Our ref: XA/2026/100502/06-L01
Your ref: EN020026
Date: 13/04/26 April 2026

Sea link planning Examination.

Annex 2: Flood risk issues update

Plate 2.3 Infrastructure within fluvial flood extents

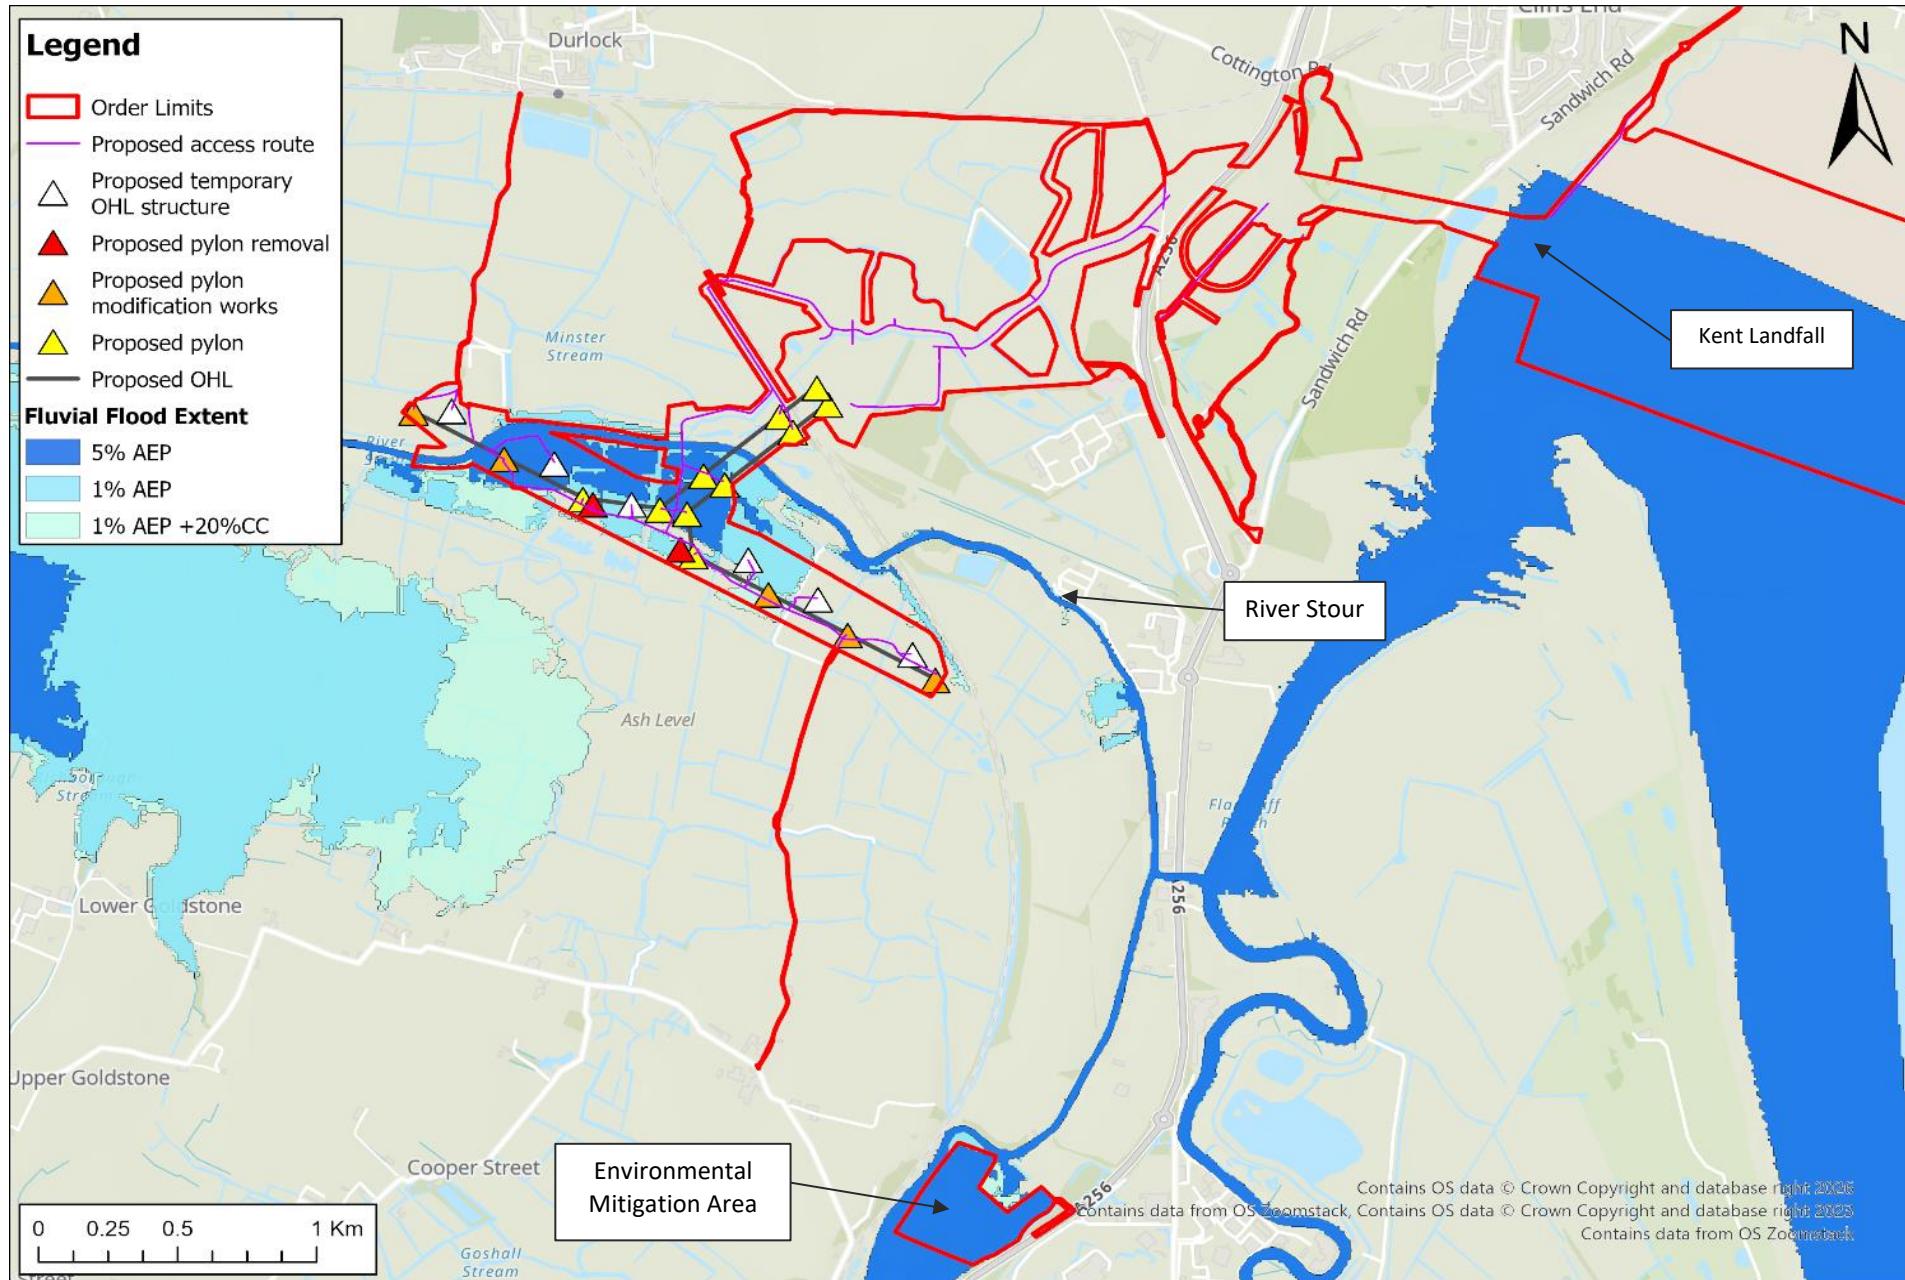
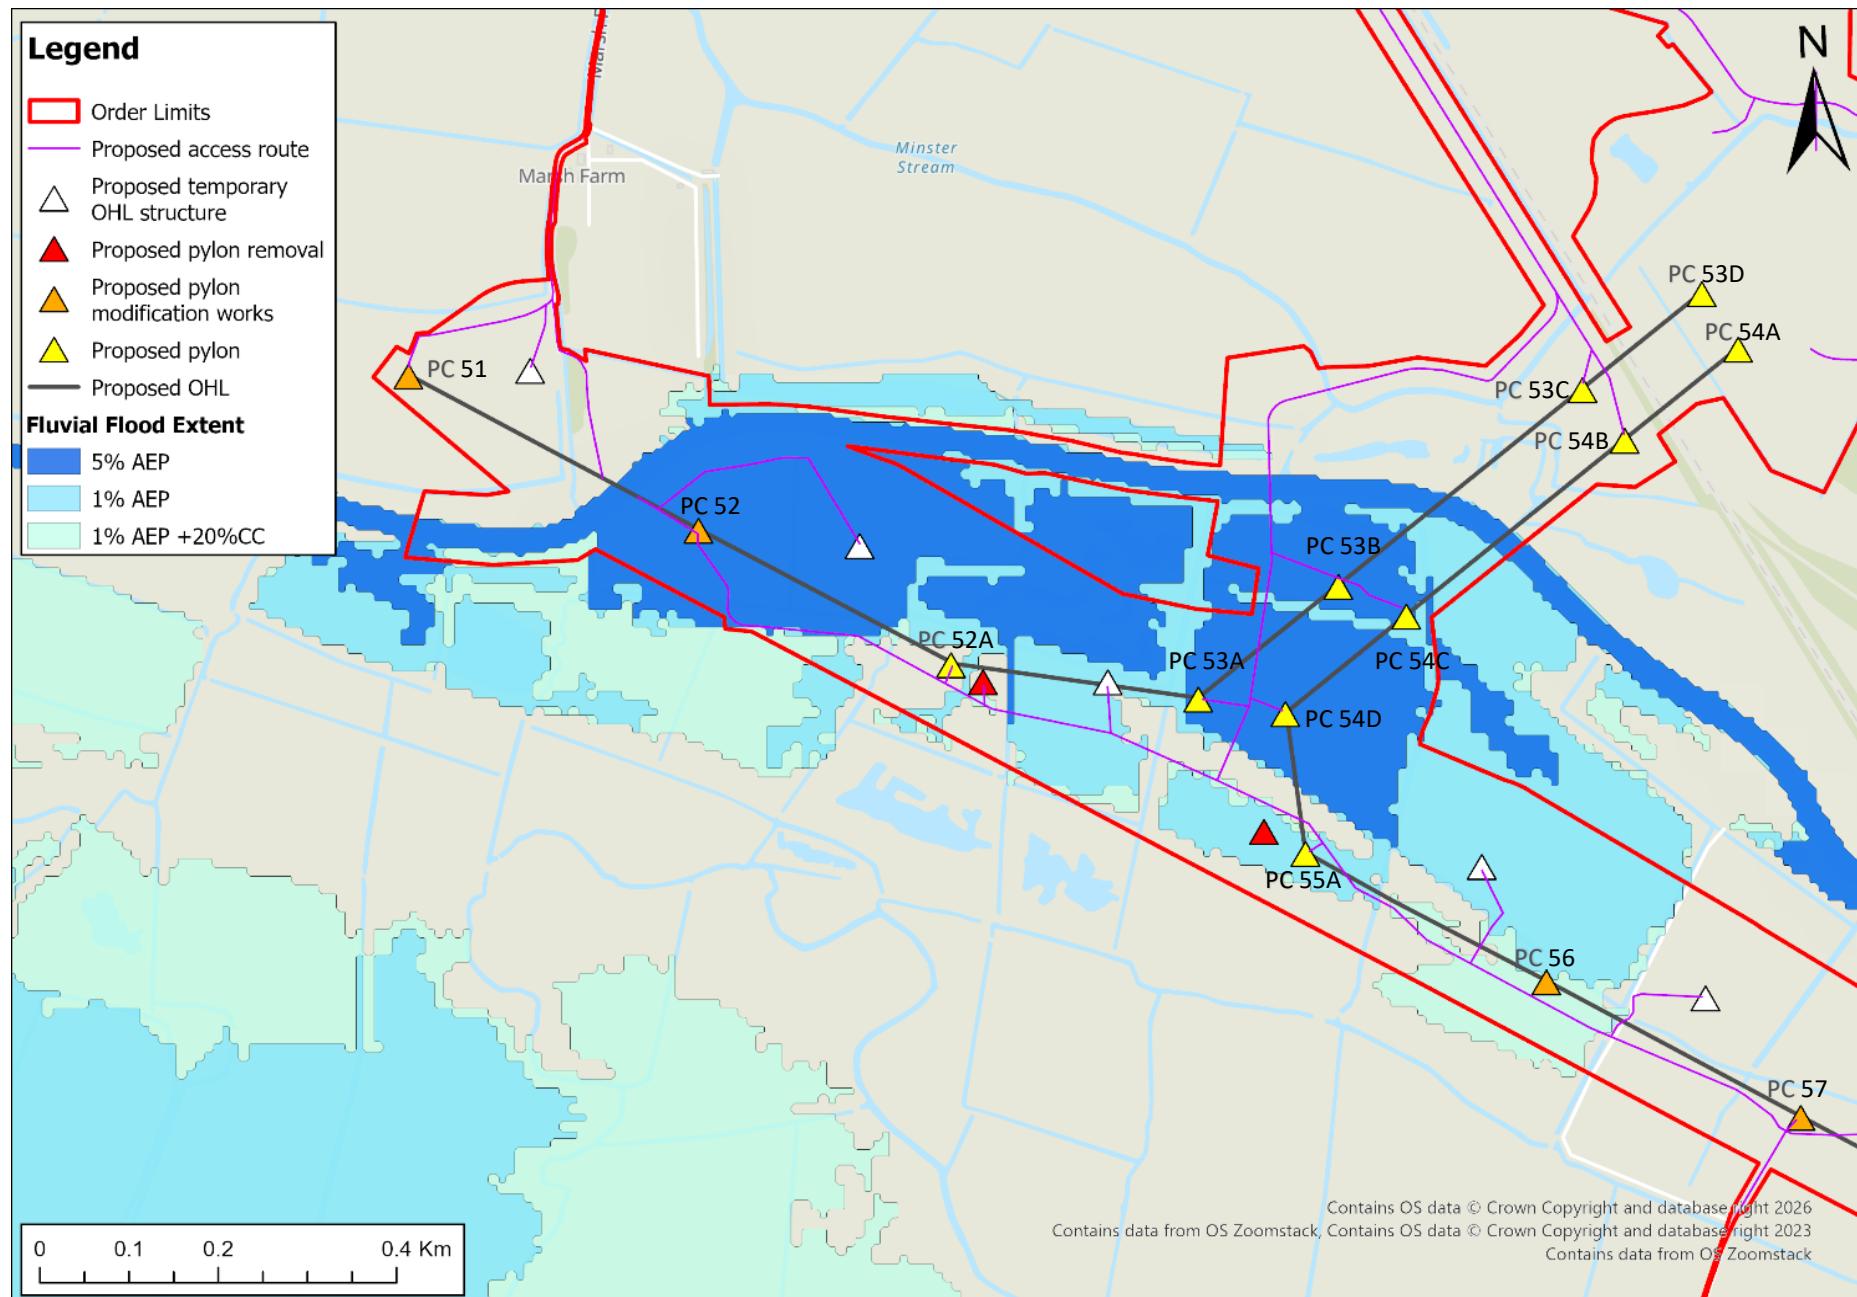
For events up to and including the 1% Annual Exceedance Probability flood events plus climate change, where pylons and a temporary drainage pond would be located within the fluvial floodplains of watercourses as part of the Kent Onshore Scheme, compensatory storage within the Order Limits will be provided for loss of floodplain storage, in accordance with a Floodplain Compensation Strategy to be agreed with the Environment Agency.

Plate 2.4 Potential floodplain compensation provision locations

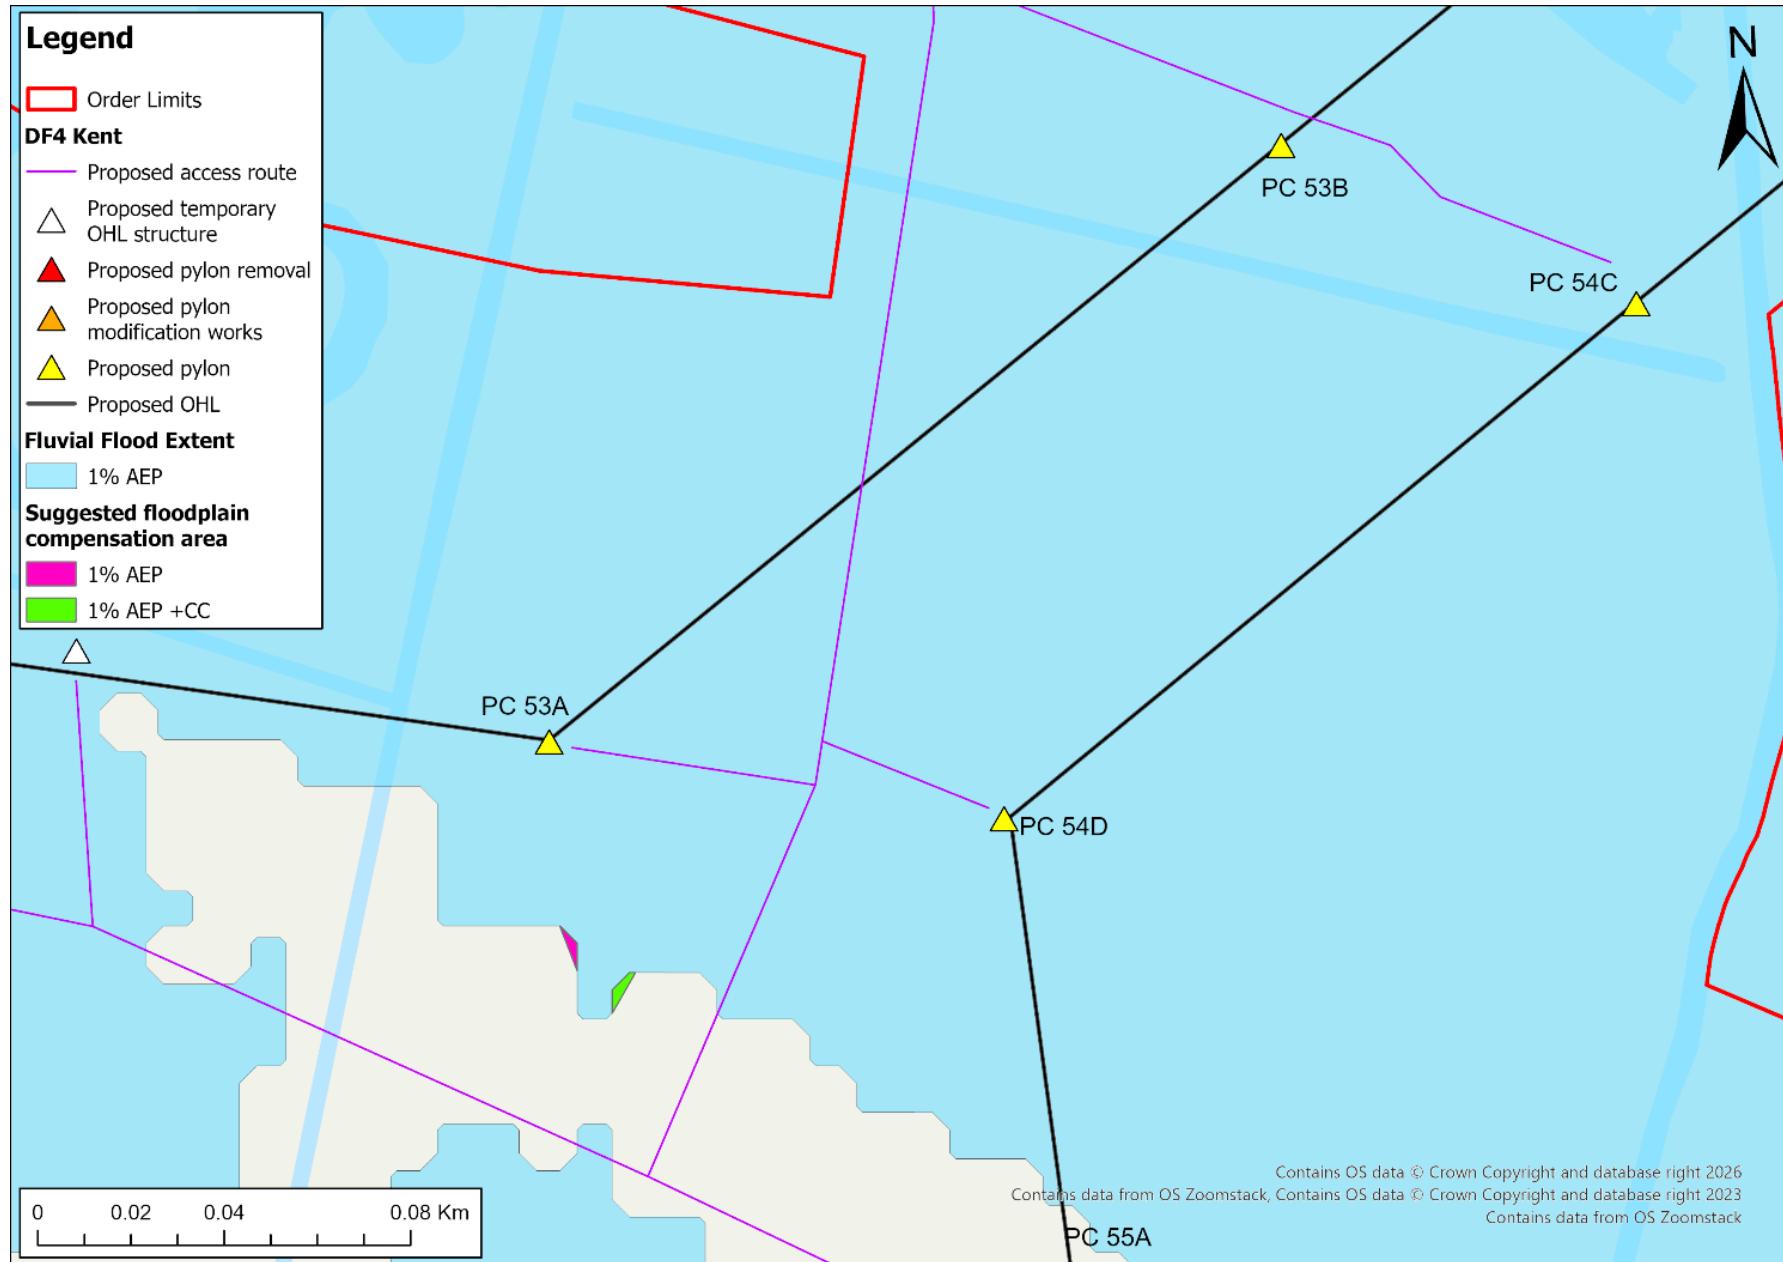
Its yet to be determined if this is going to be a requirement or if this can be resolved via other mechanisms.
